RE: After the Fact Permit - 92 West Street

Code Enforcement Officer /

Plan reviewer

# 2<sup>ND</sup> FLOOR

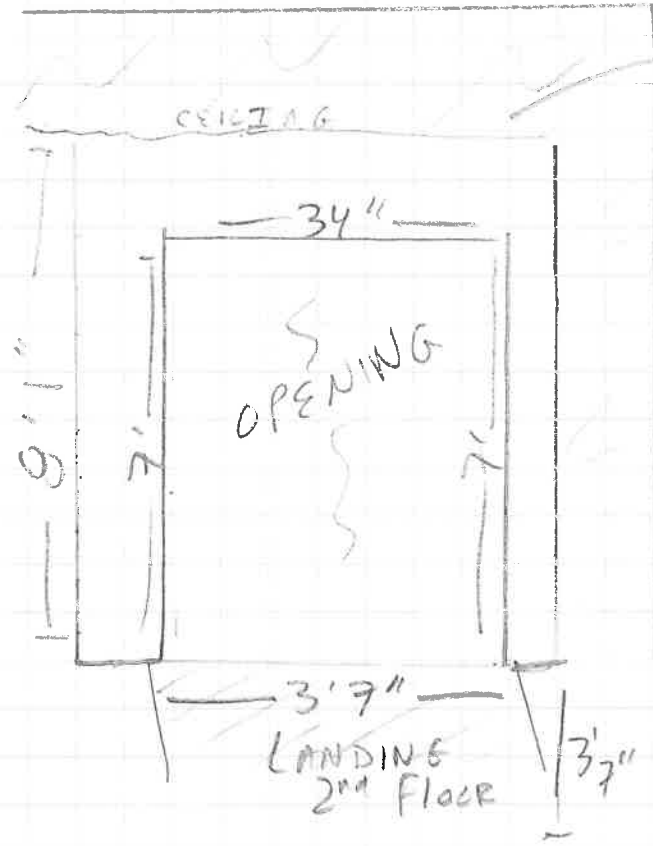
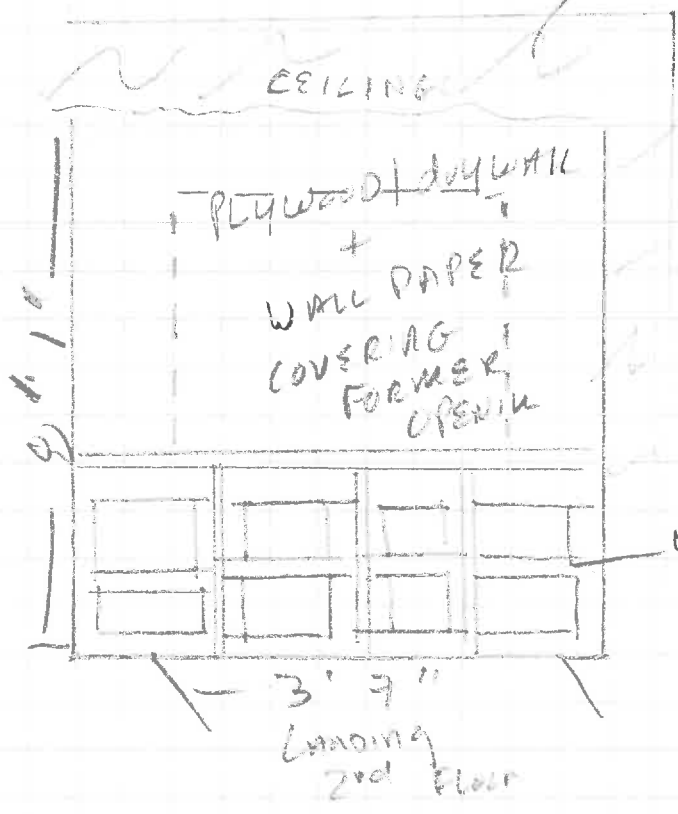
I just wanted to verify how the opening left from the previous stair was filled.

I believe you told me that it was just covered with paneling as the previous owners had done. this solution would not be a sufficient closure. that would need to be a framed wall. Can you just let me know how it was handled, and based on that i can make a note on the drawings and get the after the fact permit approved.

I did frame that space out with 2' x 4's (there was some existing framing around the opening that whoever created the opening must have installed to stabilize the opening area). I did that so I could secure $\frac{3}{4}$ " plywood on the "exterior" side of the framing (which plywood is facing inside the dormer – and not exposed to the outside elements). I think you took a picture of this side of the opening with the plywood from our bathroom window. I installed sheetrock to the inside side of the opening against the frame. That sheetrock is covered in wall paper on the top part, and by wainscoting on the bottom half. The wainscoting was installed a couple of years after we removed the stair and filled the opening.

The framing was, if I remember, every 8" or so across the opening for stability. I may have inserted insulation in there as well, but I don't know that for sure. Since it is not exposed to the exterior, I am not sure I made that a priority.

BIRDSEYE
VIEW
OF
KITCHEN/
UTILITY
ROOM

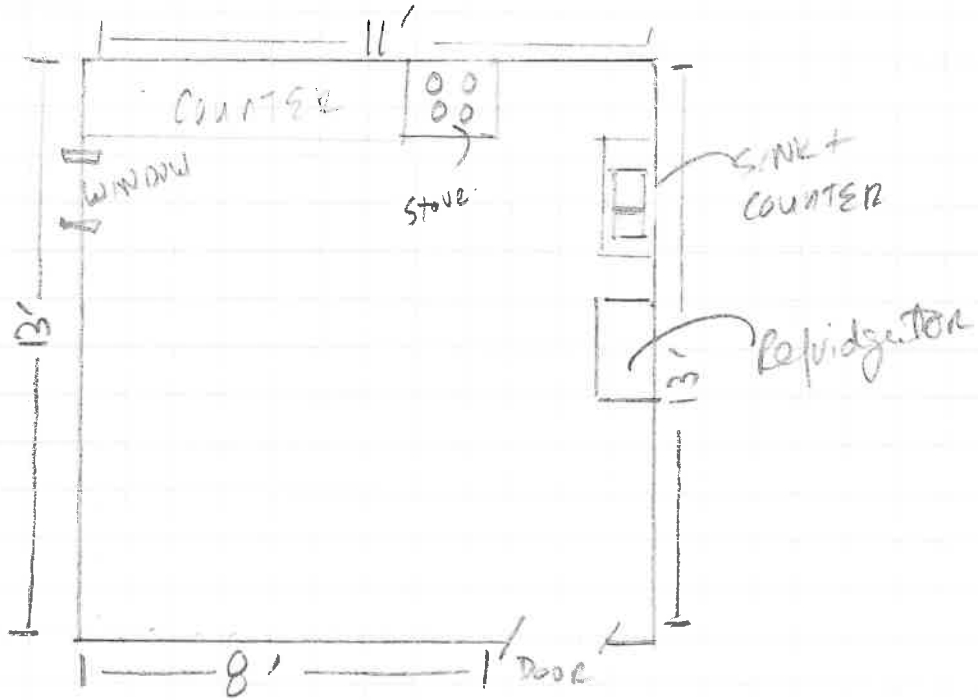
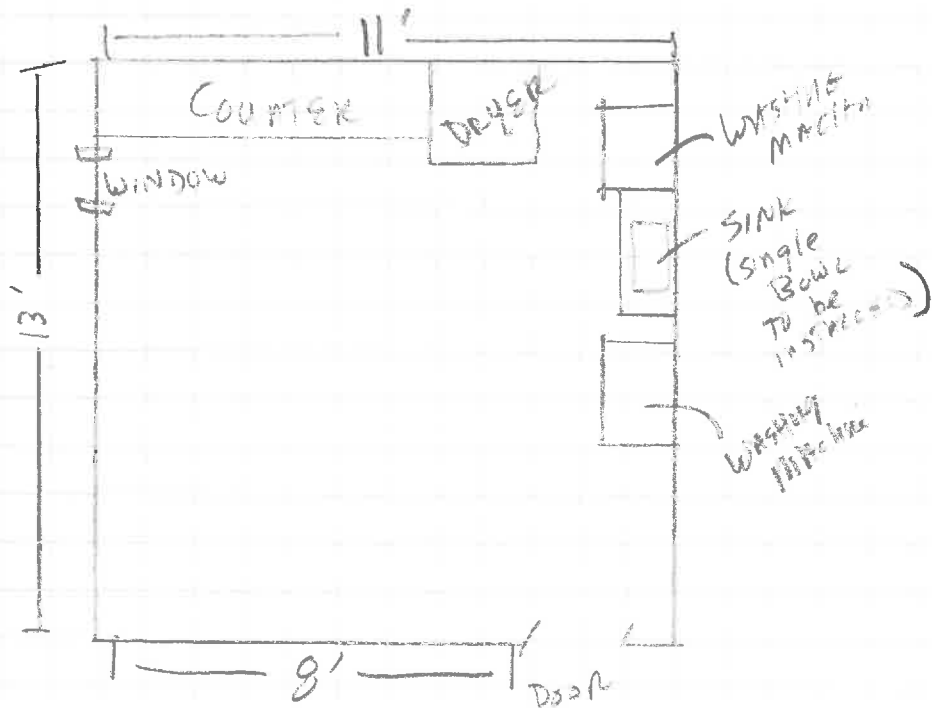
Greg, just wanted to let you know we removed the double basin kitchen sink from the 3rd floor utility room (see the attached picture). We have not decided whether we will replace it yet (or just use that space for counter space), but if we do replace it we will do so with a single basin sink as you instructed.
